SEPTEMBER 21, 2020

REQUEST

Douglas BNB, LLC requests an amendment to the approved special use permit (PCD File No. AL-09-002) to clarify existing and planned uses under the permit allowances and site plan. The amended request includes:

PROJECT DESCRIPTION

THE HIDEAWAY: RECREATION CAMP/RETREAT CENTER
 Colorado Springs, CO
 SPECIAL USE SITE PLAN MAP

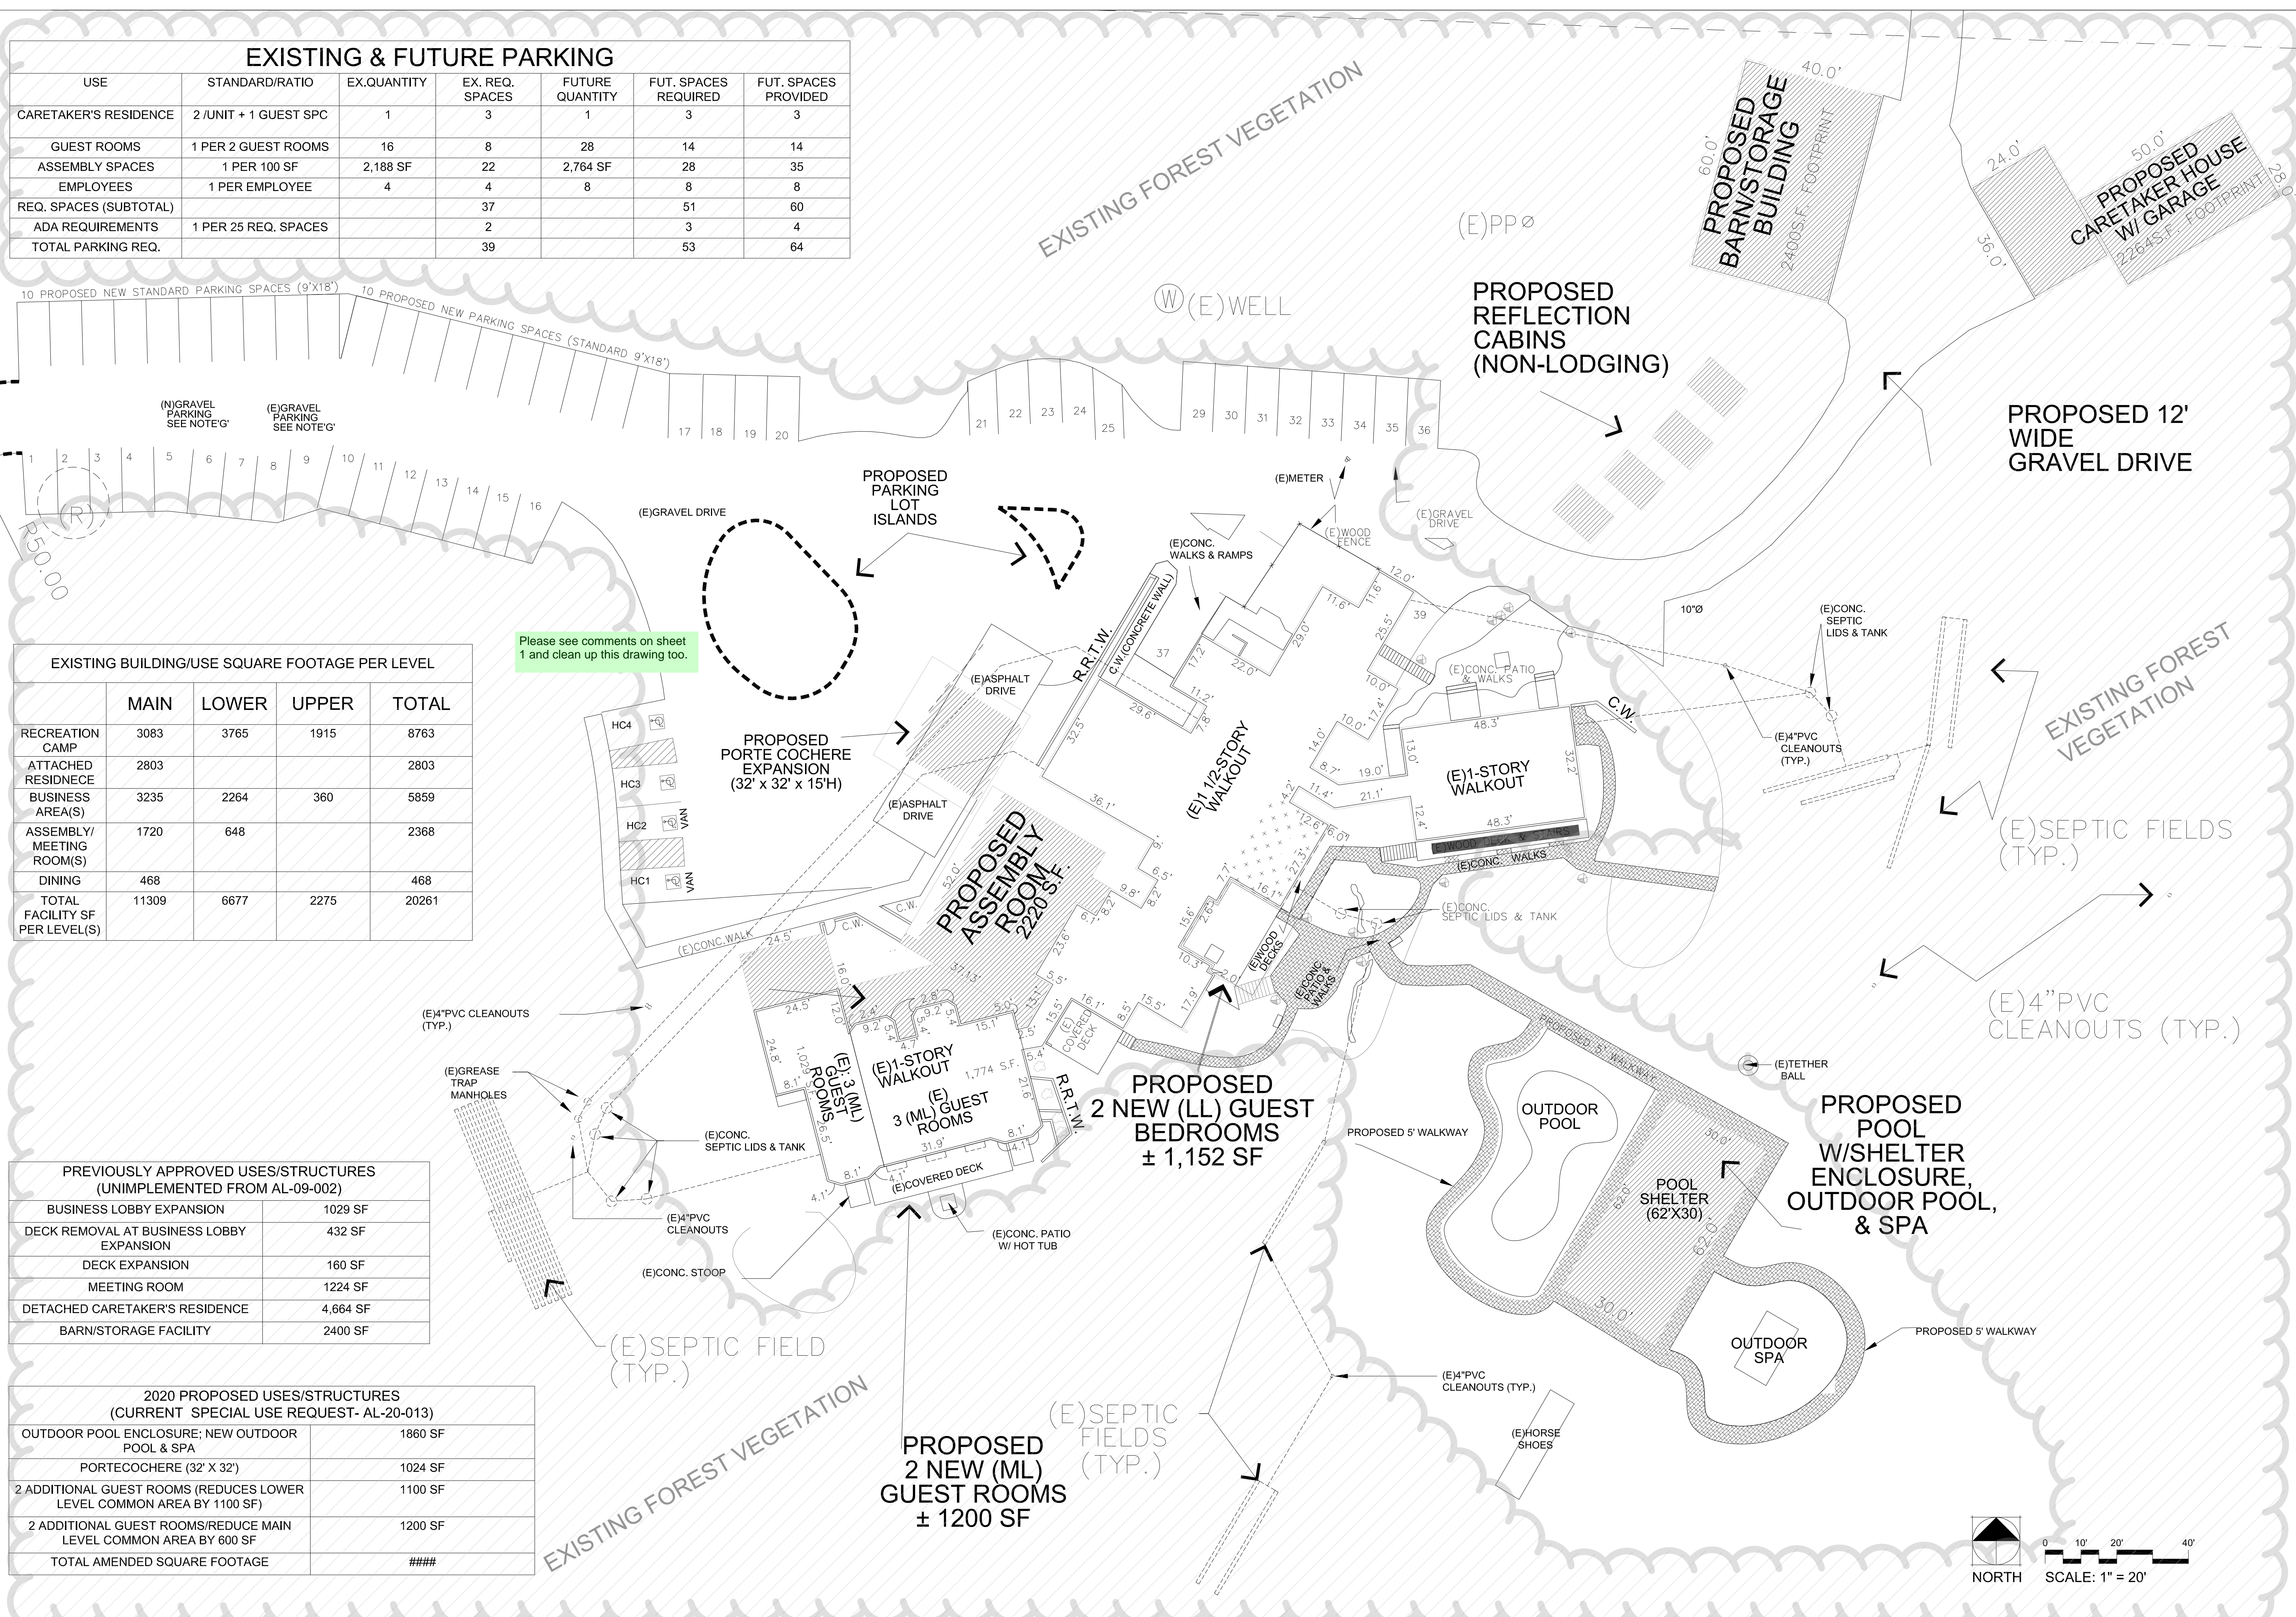
This does not match the SF shown on the site plan.
